CITY OF PORTLAND, MAINE
 DEVELOPMENT REVIEW APPLICATION
 PLANNING DEPARTMENT PROCESSING FORM

single Family Home lot#7

RE: Lot #11 Ballpark Drive - #371-A-041- R-2 Zone – application #05-0461

PROJECT NAME:	BALLPARK DRIVE LOTS 10-12
PROJECT LOCATION:	WASHINGTON AVE, PORTLAND, MAINE
CLIENT:	
PROJECT NO.:

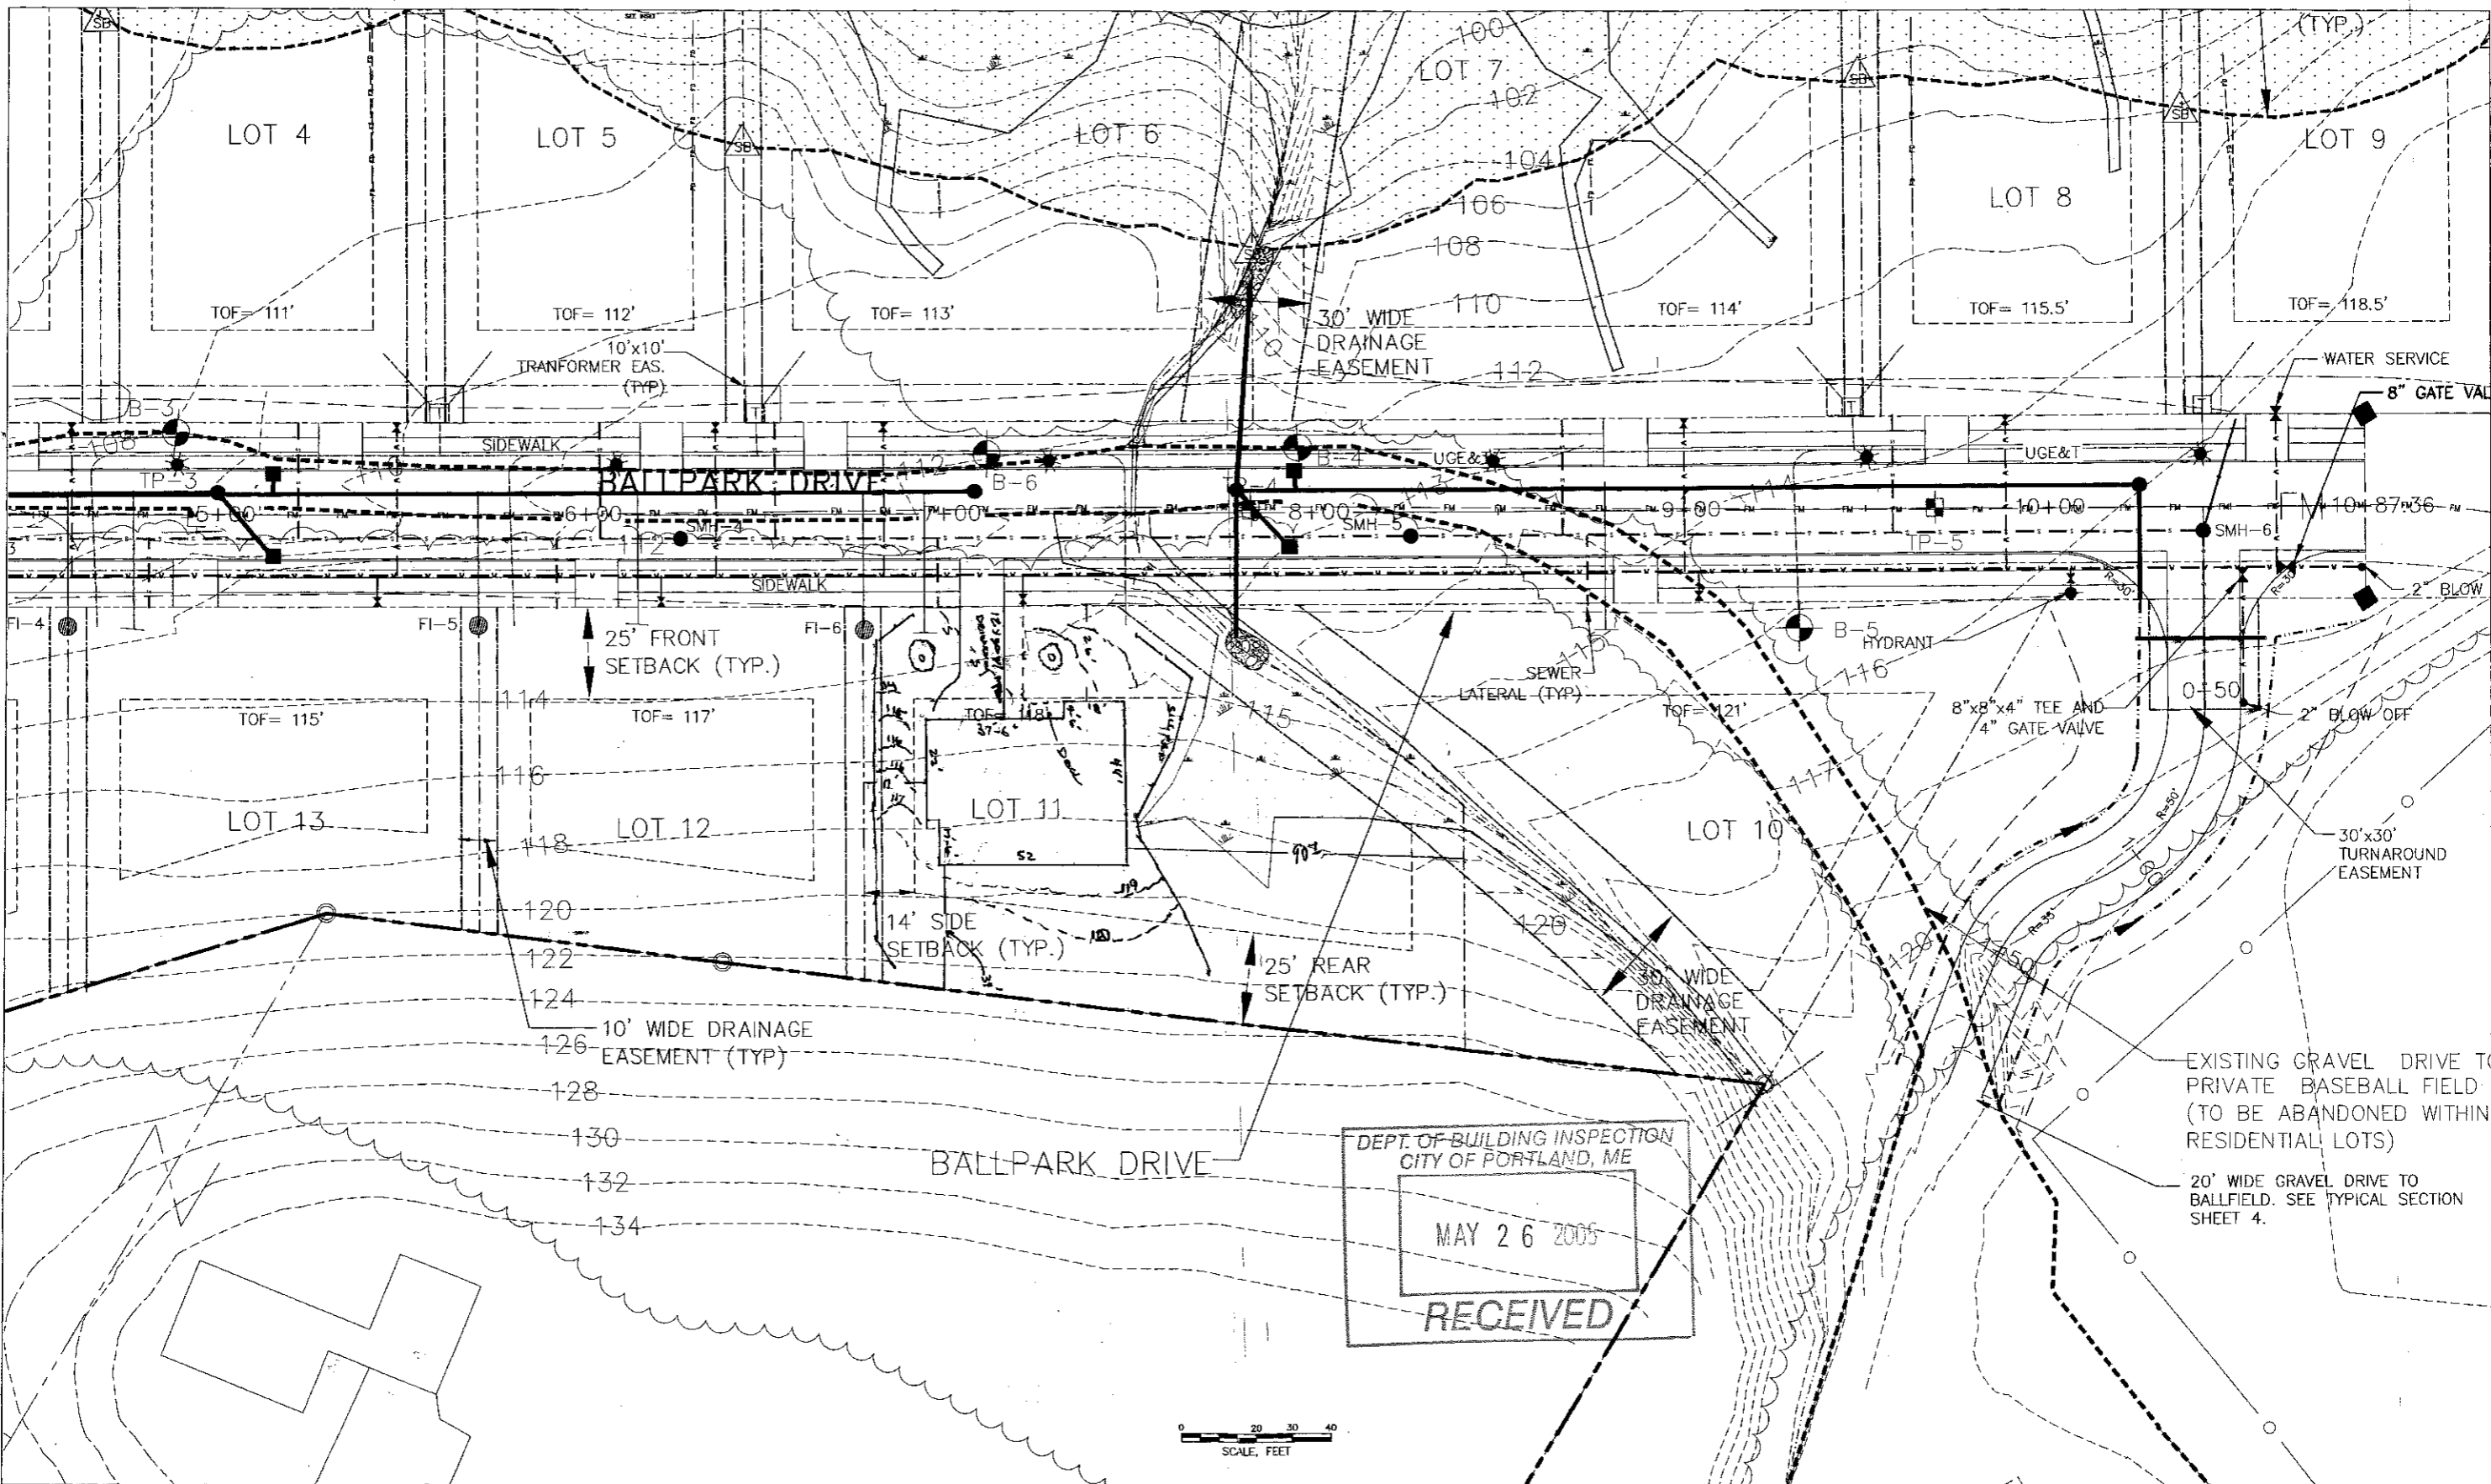
You have not submitted a scaled site plan showing the proposed, dimensioned structure. Your currently submitted site plan does not match your submitted building construction plans. Your site plan must show all projections, including, but not limited to, decks, stairs, chimneys, and bay windows.

house, existing/proposed topography, utilities, driveway, street trees, buffer zone area, finish floor elevation, etc., methods, erosion control... etc.
Any questions, call.
